DELEGATED HOUSEHOLDER DECISION

Item No.	Report of the Head of Development Management and Building Control	
Address:	33 HAZELWOOD DRIVE PINNER	
Development:	Erection of a part single storey, part two storey side and a single storey rear extension together with associated parking and landscaping.	
LBH Ref Nos:	6342/APP/2024/1678	
Drawing Nos:	ND/HD/00 ND/HD/01 ND/HD/02 ND/HD/03 ND/HD/04 ND/HD/05 ND/HD/06 ND/HD/07 ND/HD/08 ND/HD/09 ND/HD/10 ND/HD/11 Flood Risk Assessment 2554	
Date Plans received:	26-06-24	Date(s) of Amendments(s):
Date Application valid	31-07-24

Project	Dr. No.
RESIDENTIAL	ND/HD/11

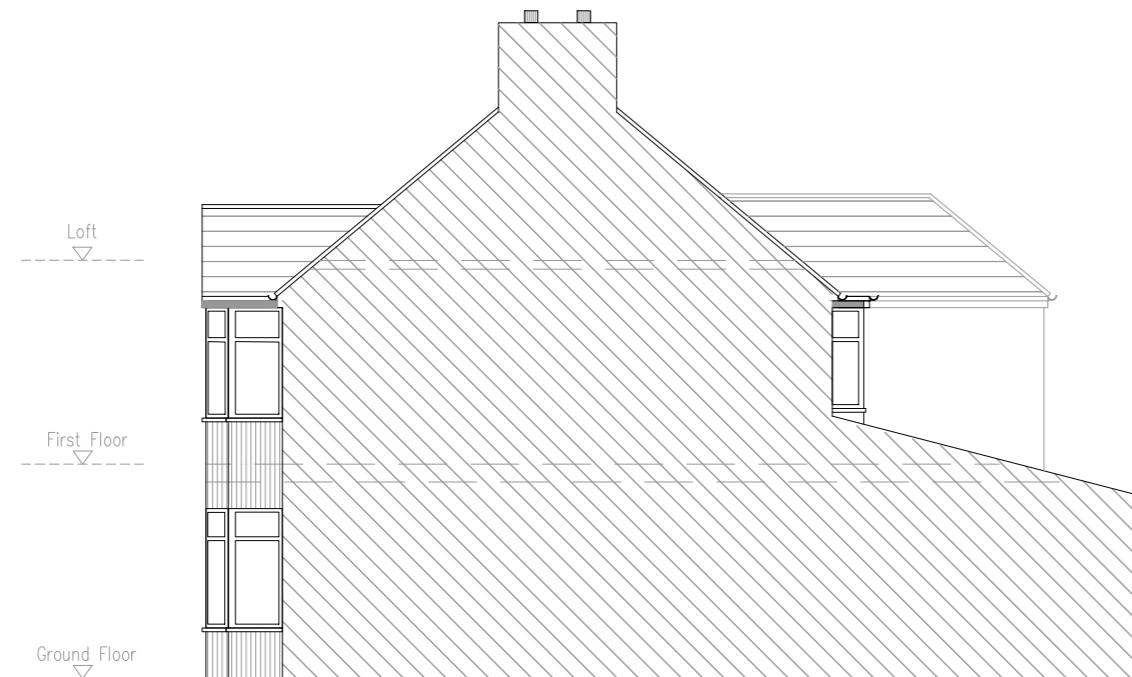
The single storey rear extension, with a depth of 4.00m would be slightly in excess of the depth of 3.60m set out within Policy DMHD 1 of the Hillingdon Local Plan: Part Two - Development Management Policies (2020). Despite this, given the replacement nature of the proposal and the surrounding context, it would be considered acceptable in this instance.

The single storey part of the side extension, with a width of 4.00m would be in excess of half the width of the original dwelling, contrary to Policy DMHD 1 of the Hillingdon Local Plan: Part Two - Development Management Policies (2020). The first floor element of the side extension, with a width of 3.00m, would also be in excess of half the width of the original dwelling. Despite this, given the site context, the size of the plot, the proposed side extension would be considered acceptable in this instance.

Number 35 Hazelwood Drive benefits from a single storey extension with a depth of approximately 3.20m. Given this, the proposed extension would protrude 0.80m further than the extension at No 35. Due to this modest projection, it is not considered that the proposal would negatively impact the amenity of this neighbour, in terms of daylight, sunlight, outlook or overbearing effect.
